Job ID: 2012-09-4996-ALTCOMM

**Benjamin Wallace - Allagash Brewery - 50 Industrial Way - permit 2012-09-4996-ALTCOMM**

Hi Michael,  
I have the Allagash permit and a few questions I need clarified.

NEW ADDITION FOR ALLAGASH BREWING COMPANY  
50 INDUSTRIAL WAY ; PORTLAND ; MAINE 04103

1 FIRST FLOOR NEW ADDITION CODE COMPLIANCE PLANS
SCALE: 1/8" = 1'-0"

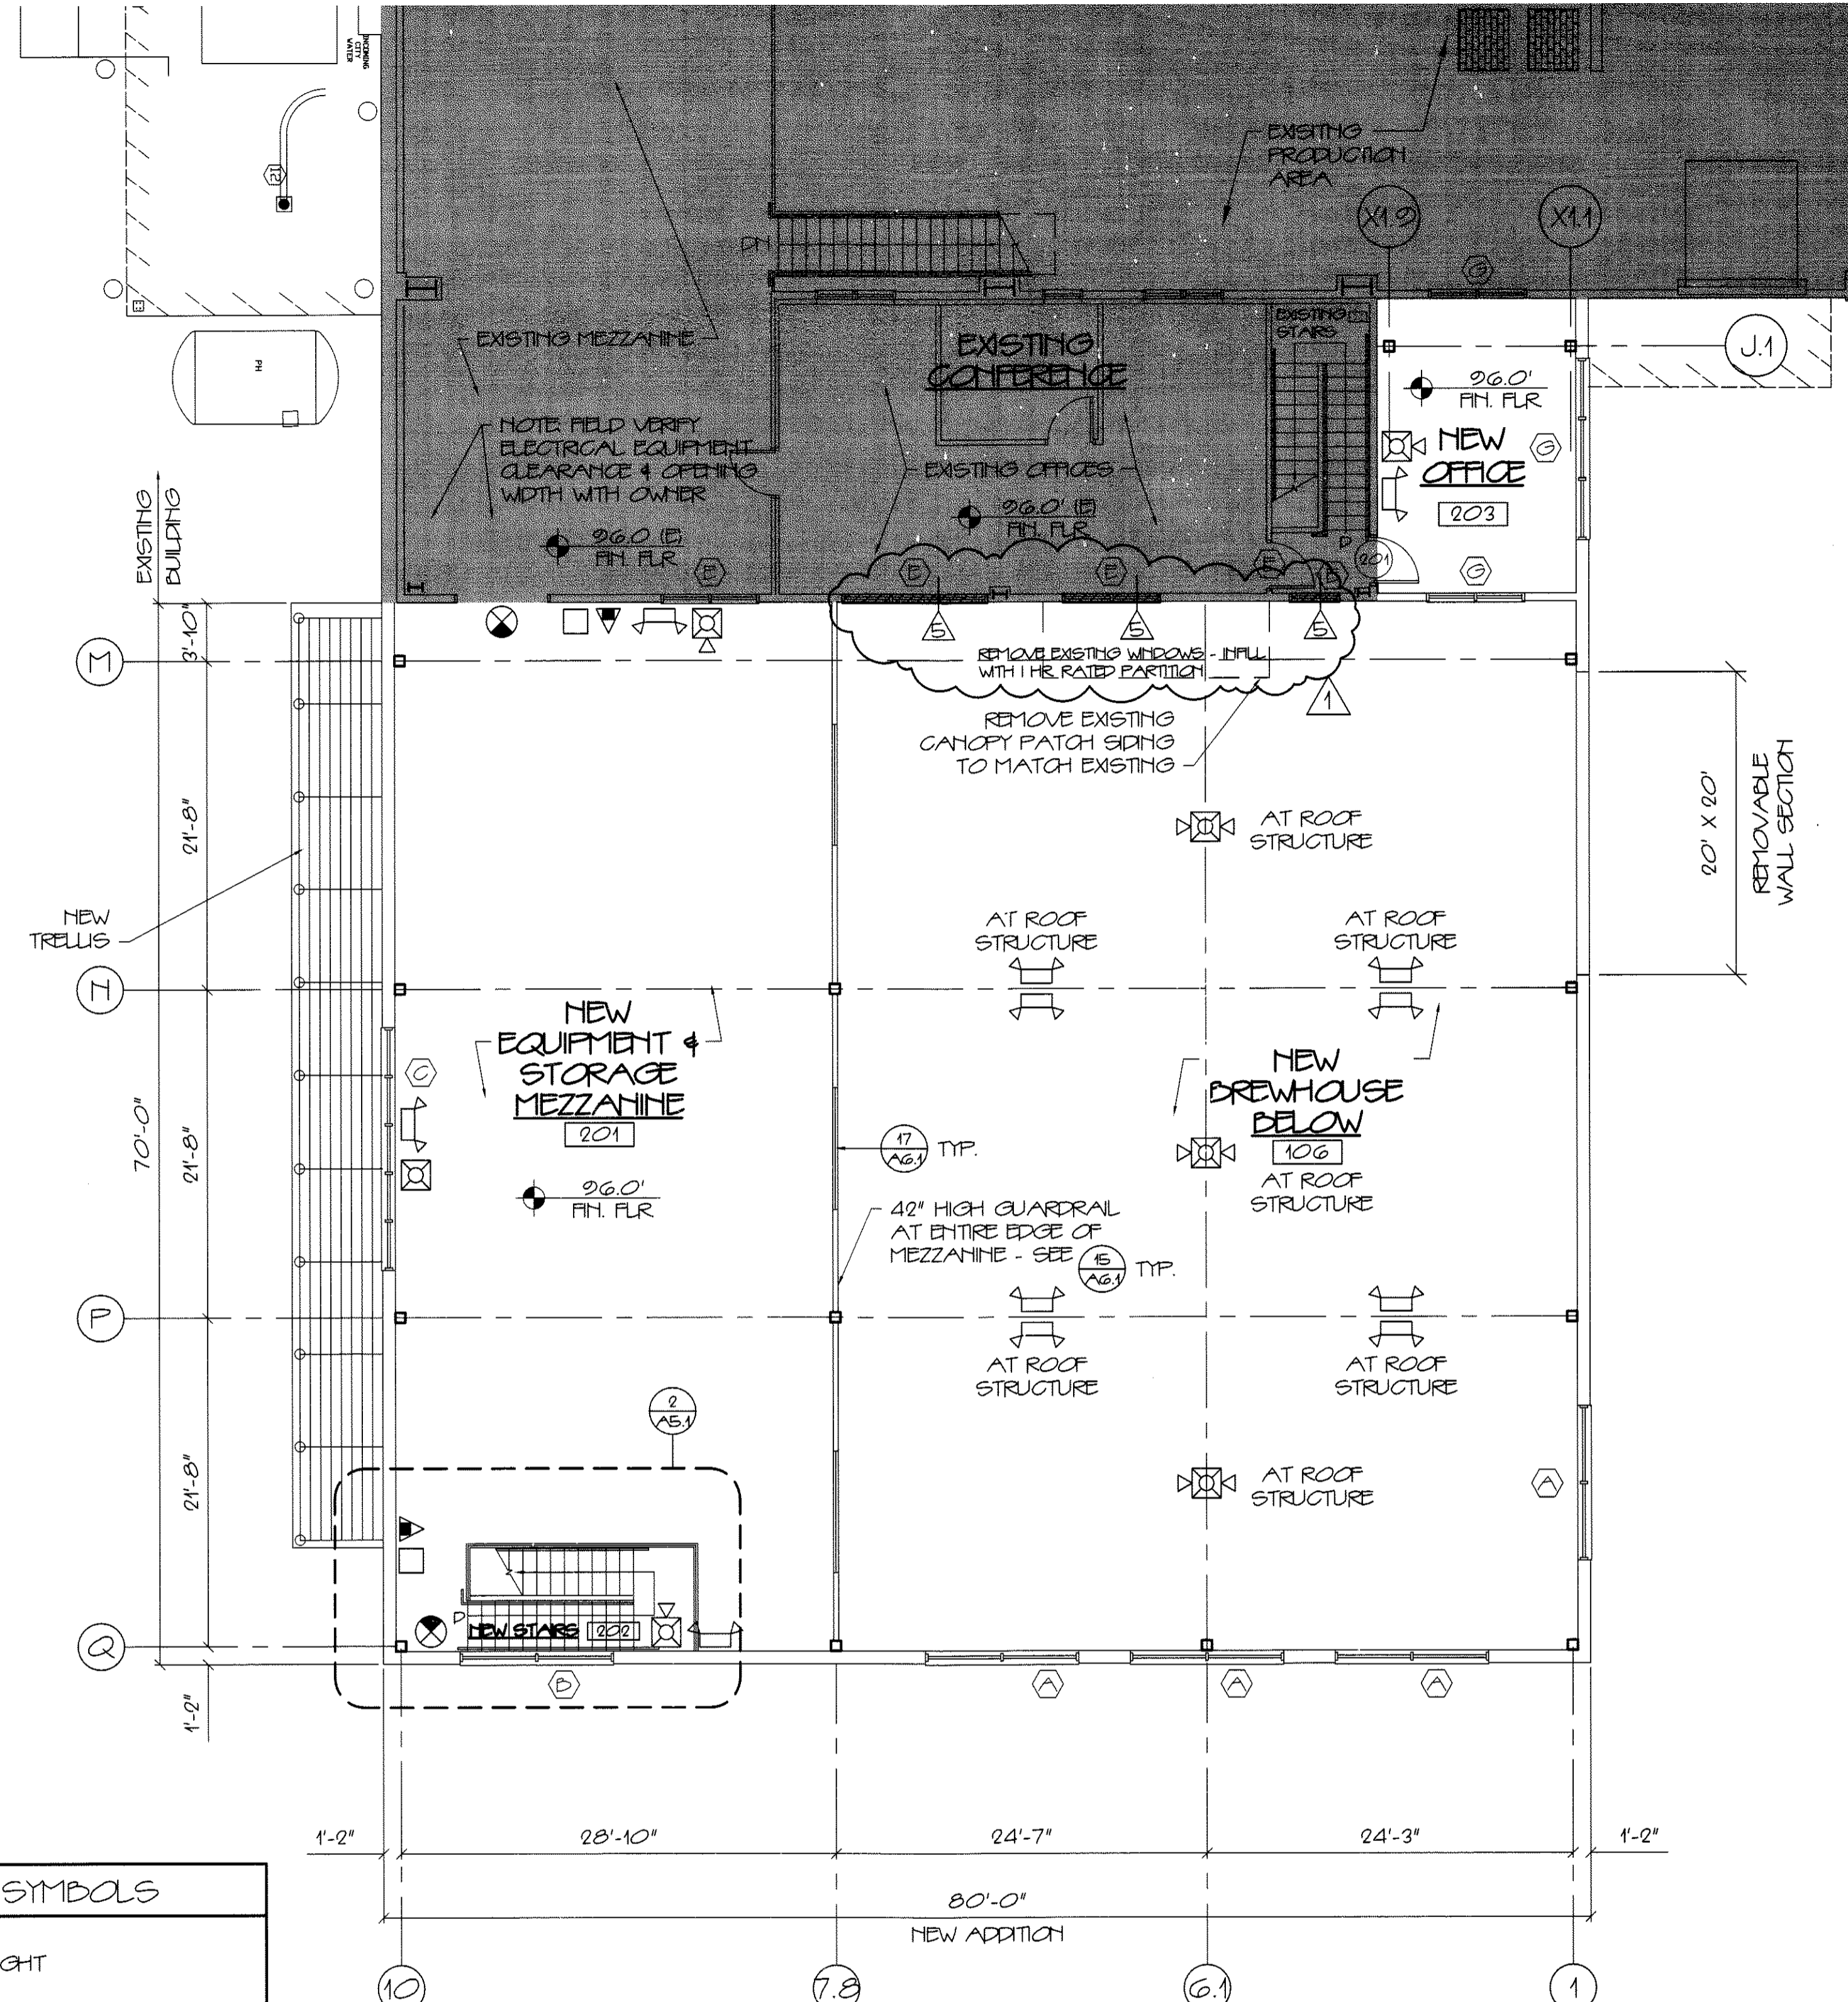
1. What is the occupancy sub-classification (NFPA 101:40.1.4.1)? I'm not sure this meets the intent of Special-Purpose Industrial so I think it's general purpose industrial.

2. The "mezzanine" does not appear to meet the area limitations of 101:8.6.9.2. Please explain if it is a mezzanine in accordance with the *Life Safety Code* or a story and how that affects your exits and separation of stories.

3. The plans show 1-hour wall separation between the new mercantile area and the Brew House but not from the "mezzanine" above or the production area in the existing building where the mercantile is currently located. The North wall of the new mercantile space was an existing exterior wall with windows and a door and is assumed to have no fire resistance rating. Please explain both.

4. The existing exit stair from the second floor office space currently discharges directly outside. The South and East exit stair walls are assumed to have no fire resistance rating. Please explain this and also how the single exit from the new office space is allowed to discharge through the level of exit discharge (Brew House) which might be considered a hazardous area. Please also consider 101:40.2.5.1 when explaining.

7. The new stair from the mezzanine is not enclosed at the top as required by 101:7.2.2.5. Please explain.
8. Please explain if the fermentation tank bunkers are required to be protected by sprinklers under the scope of NFPA 13, *Standard for the Installation of Sprinkler Systems*, 2007 edition. It looks like they are covered by the building's roof and may have walls around them?

DOOR SCHEDULE

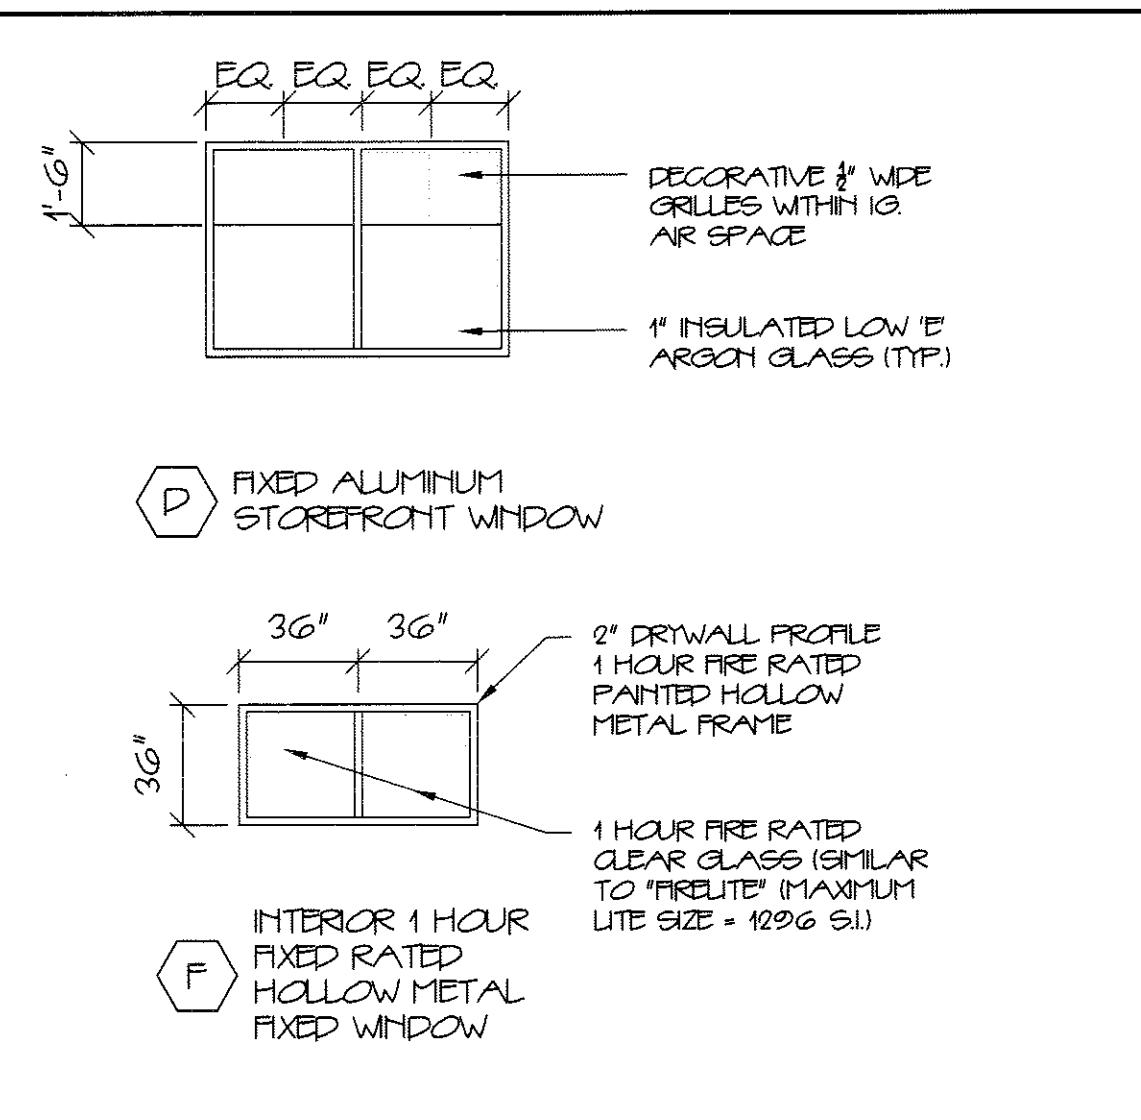
5. Door 108 is not listed on the door schedule. What is its fire resistance rating?
6. The Brew House does not have the required remoteness; 51'-6" as indicated on your plan. An overhead door can not be used as an exit door and the replacement door is not listed on the door schedule. Please explain.
